## WEST SUSSEX COUNTY COUNCIL CONSULTATION

| <b>LOCATION:</b>                | Land at Electricity Sub Station<br>Ford Road<br>Arundel<br>BN18 9DX                                                                                                                        |
| <b>SUBJECT:</b>                 | AB/88/19/PL<br><br>38 No residential apartments (9 No 1-bed units & 29 No. 2-bed units) along with access, off-street parking, amenity space & enhancements to the local footpath network. |

CARPORT (SECTIONAL)

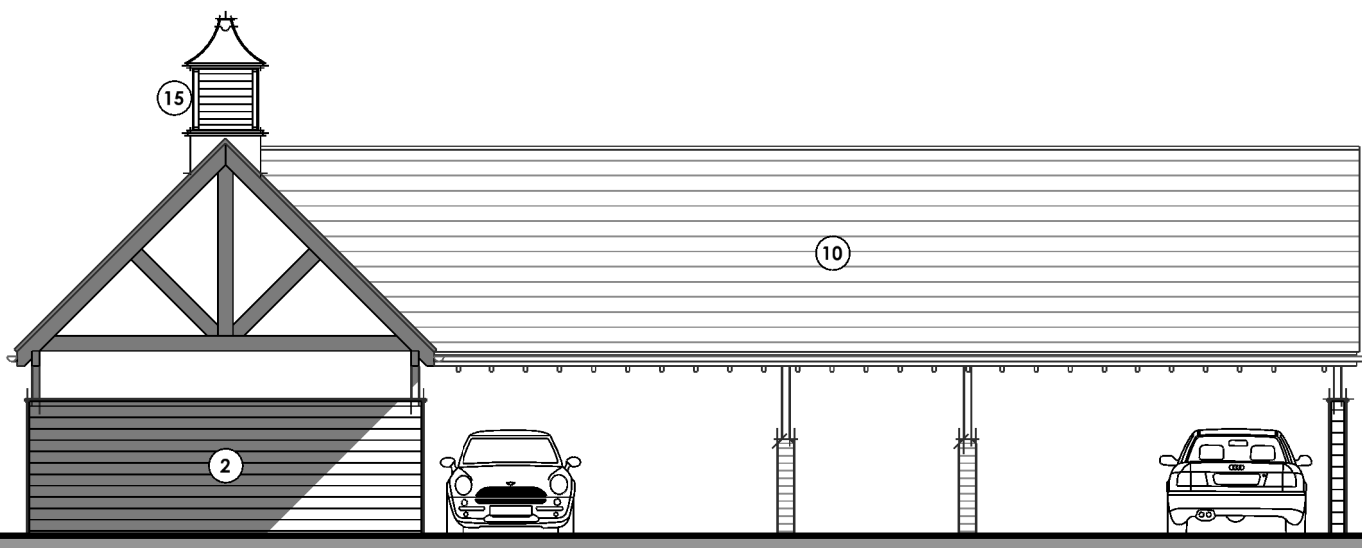
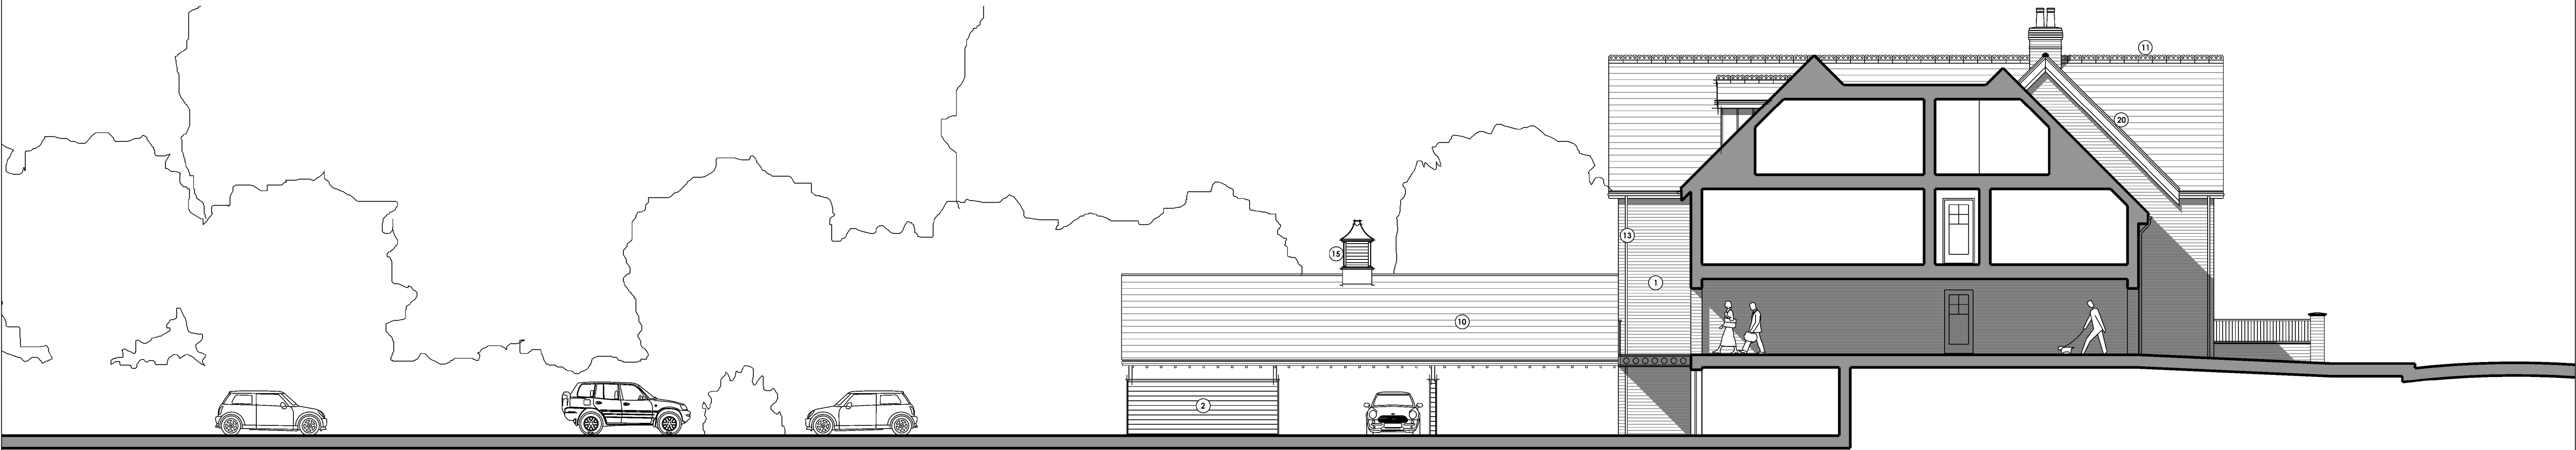
- Visitor Cycle Parking - No updated drawings have been provided to detail this. It is noted that a condition could be imposed to control this.
- Height of the raised deck - the applicant has confirmed that the raised deck would have a minimum clearance of 2.5m however this has not be detailed in any plans. Without the revision concern is raised about the ability for vans and supermarket delivery vehicles to access the site which is likely to result in vehicles parking along the access road/right of way. In addition the applicant has not provided any information to detail if the demands of these vehicles could be accomodated on the highway network in the vicinity of the site.

Due to the insufficient head room the proposal does not include adequate provision on the site for the parking of vehicles in a satisfactory manner to the standard required by the Local Planning Authority.

Should the applicant submit revised details as advised then this reason for refusal would be addressed.
